Your Ref: OWPC18516
Our Ref: WA/26/18/OUT 22-03-2018
Please ask for:
Mr J Baeza

Outline application with all matters reserved for 6 No detached houses with detached garages. This application is a Departure from the Development Plan.

Former Lanes End House Adjacent to West Walberton Lane & Arundel Lane Walberton

Thank you for your internet representation made on 30th May 2018 which has been recorded as '**an objection**' with the comments as follows:

Former Lanes End - Six Six bedroom detached Houses with Garages Proposed Layout Scale 1:100 @ A3 (c) PJ Developments LTD 2018		REVISIONS		01
		MM/DD/YY	REMARKS	
	1	--/--/--	...	A
	2	--/--/--	...	
	3	--/--/--	...	
	4	--/--/--	...	
	5	--/--/--	...	
West Walberton Lane Proposal

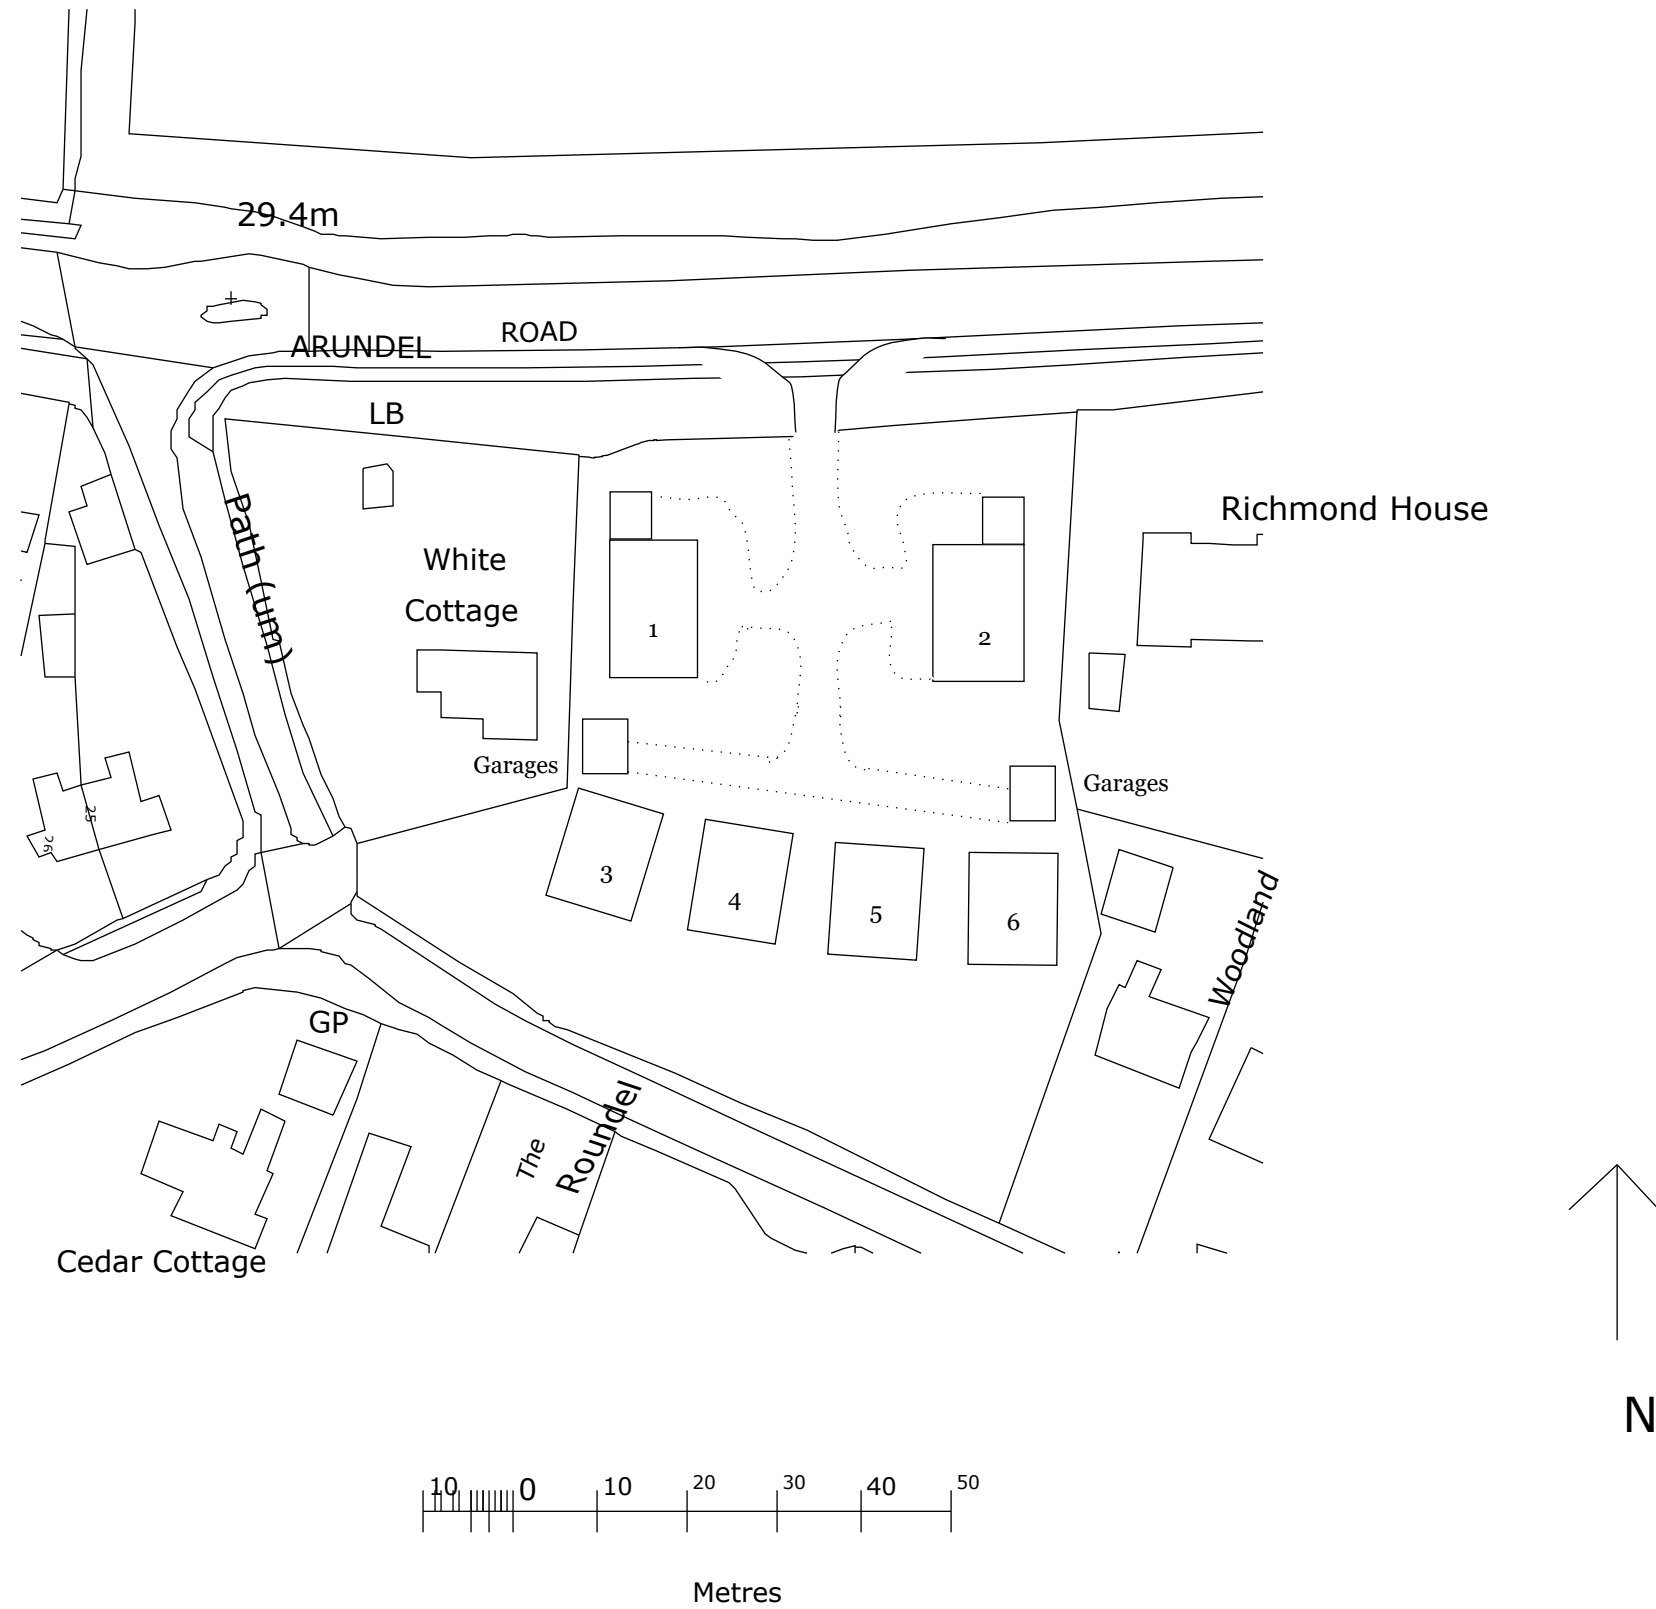
I think this proposal would overdevelop this plot. 6 small houses as proposed would be out of keeping with this rural area where adjoining properties are larger houses in substantial plots.
